WEST SUSSEX COUNTY COUNCIL CONSULTATION

TO:	Arun District Council FAO: S Davis
FROM:	WSSC – Highways Authority
DATE:	30 June 2026
LOCATION:	Rabbit Island Rear of 84 Brooks Lane, Bognor Regis, PO22 8DN
SUBJECT:	FP/66/26/PL Retention of an existing agricultural barn previously approved under FP/106/23/AG with a total roof height of 4.2m (compared to 2.9m as permitted). This application is in CIL Zone 5 (Zero Rated) as other development.
DATE OF SITE VISIT:	n/a
RECOMMENDATION:	Advice

This application is for the retention of an existing agricultural barn previously approved under FP/106/23/AG with a total roof height of 4.2m. The site is located off Brooks Lane, an unclassified road subject to a speed restriction of 30 mph.

Drawing: Elevations and floor plan

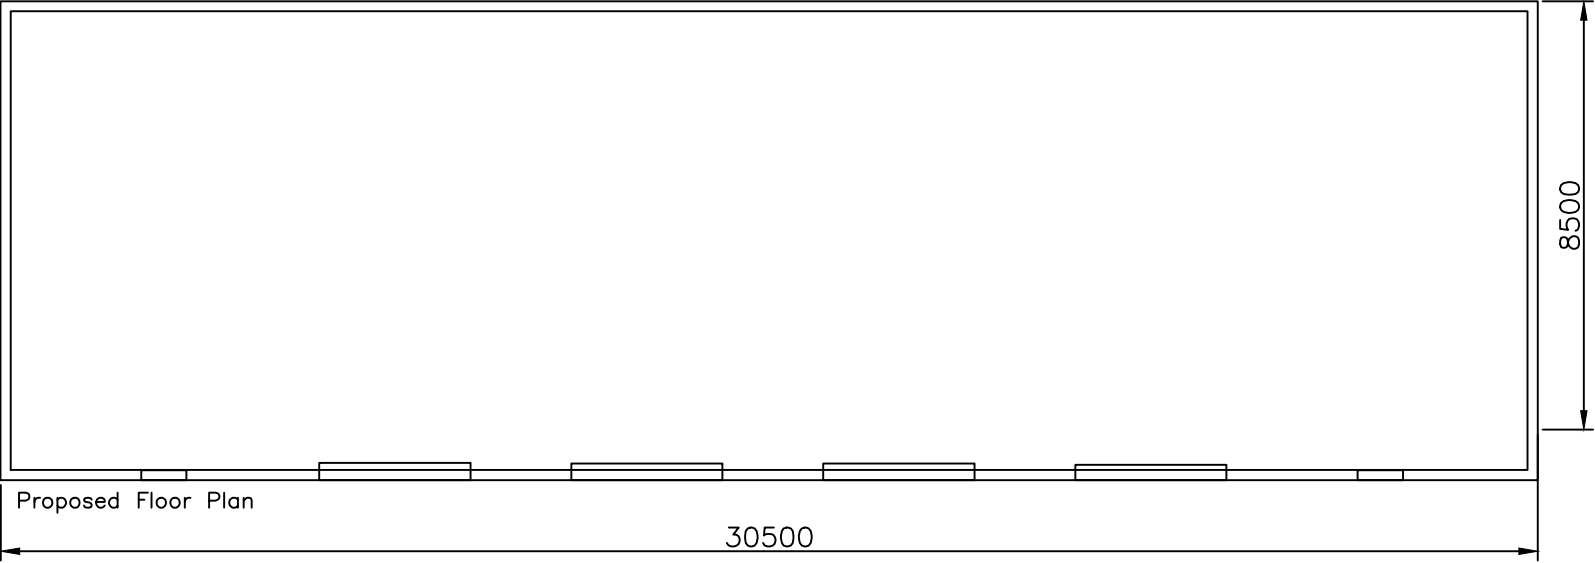
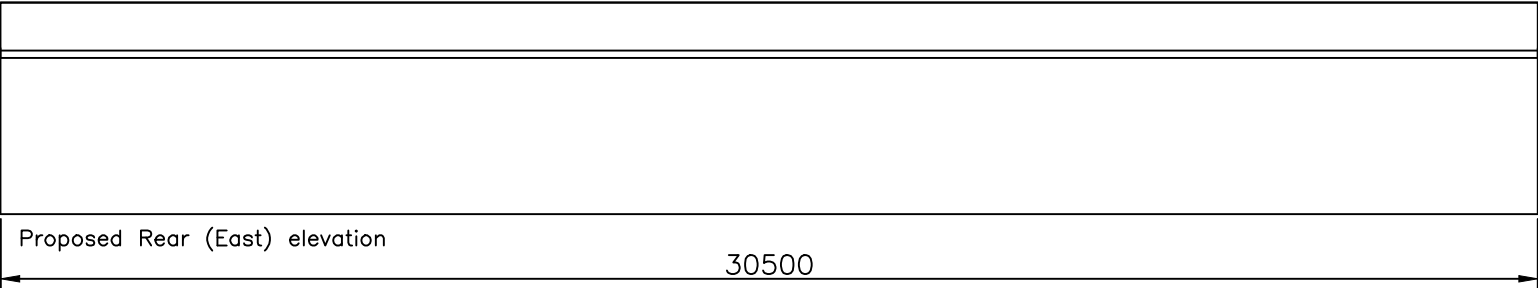
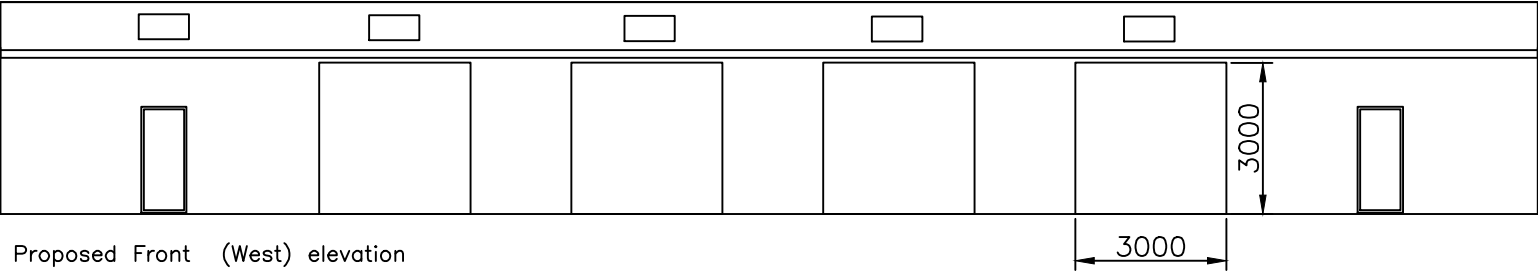
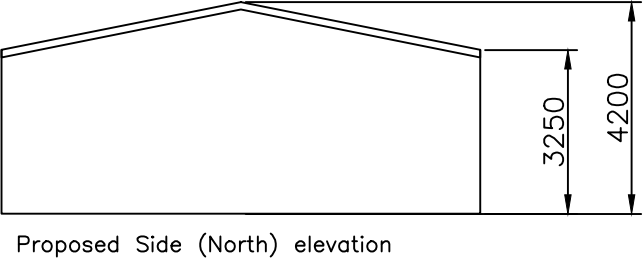
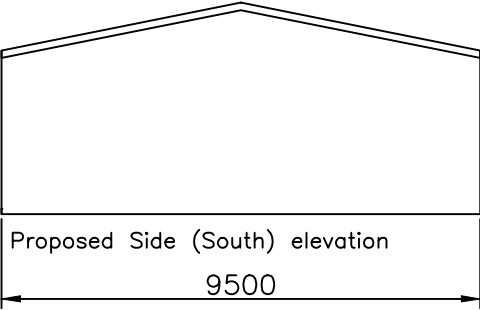
From inspection of the plans, the barn is located on private land outside of the highway boundary and is located such that it will not affect vehicular visibility at the existing access. The LHA does not anticipate that the proposed development would give rise to a significant material intensification of movements to or from the site.
